Hunter New England Local Health District
Hunter New England Population Health
Direct Contact Details
Phone: (02) 4924 6494 Fax: (02) 4924 6490
Email: philippe.porigneaux@hnehealth.nsw.gov.au

27 April 2012

**PORT WARATAH COAL SERVICES LIMITED
ENVIRONMENTAL ASSESSMENT TERMINAL 4 PROJECT**

Figure F1: Cross-section of Predicted Maximum 24-hour Average TSP Concentrations due to Coal Dust Emissions from Rail Wagons On-route to the T4 project area

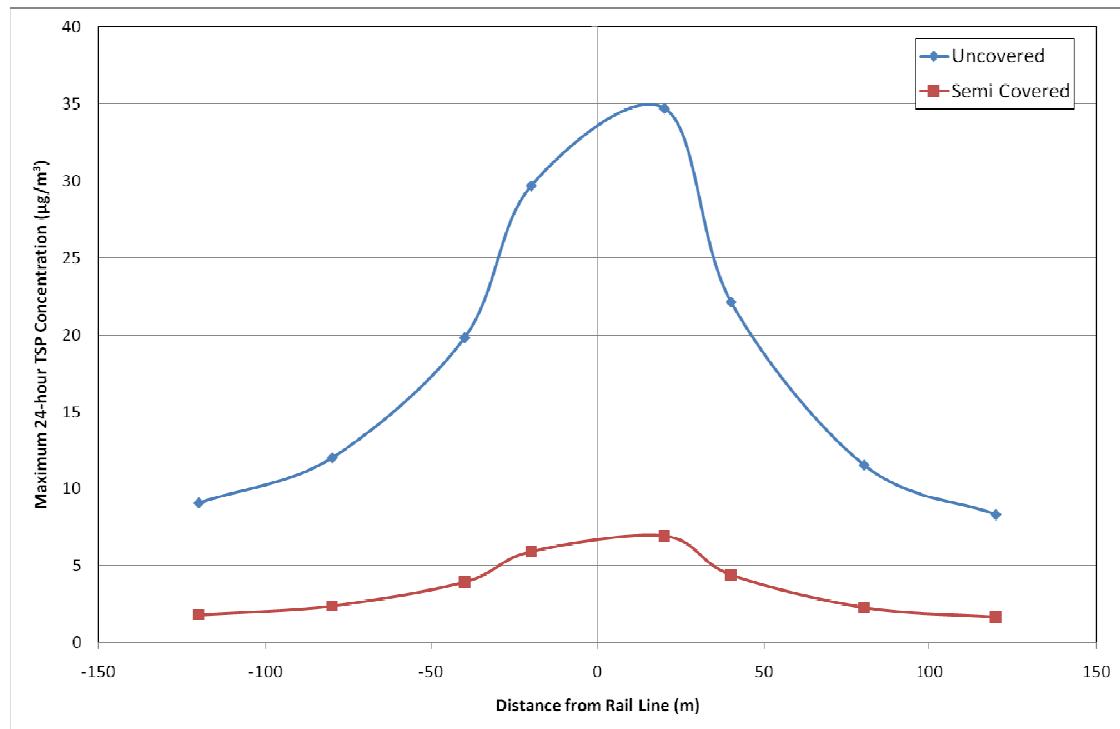
The Environmental Assessment considers that the T4 Project will have peak 24-hour PM_{10} concentrations for coal trains travelling to the T4 coal loader within the range of 3 to $13 \mu g/m^3$ within 20 meters of the rail corridor. Further, that there are some 100 houses within 20 meters of the rail corridor between The Port of Newcastle and Muswellbrook. The Environmental Assessment acknowledges that rail transport and Pollution Reduction Program along the rail corridor is not part of the T4 Project but rather within the realms of the Australian Rail Track Corporation (ARTC). There is also acknowledgement that ARTC is currently studying fugitive coal dust emissions from coal trains.

It is the view of this office that the contribution of coal dust from coal trains beyond 20 meters of the rail corridor needs to be carefully considered as a contribution to the cumulative impact on air quality and necessary mitigation strategies.
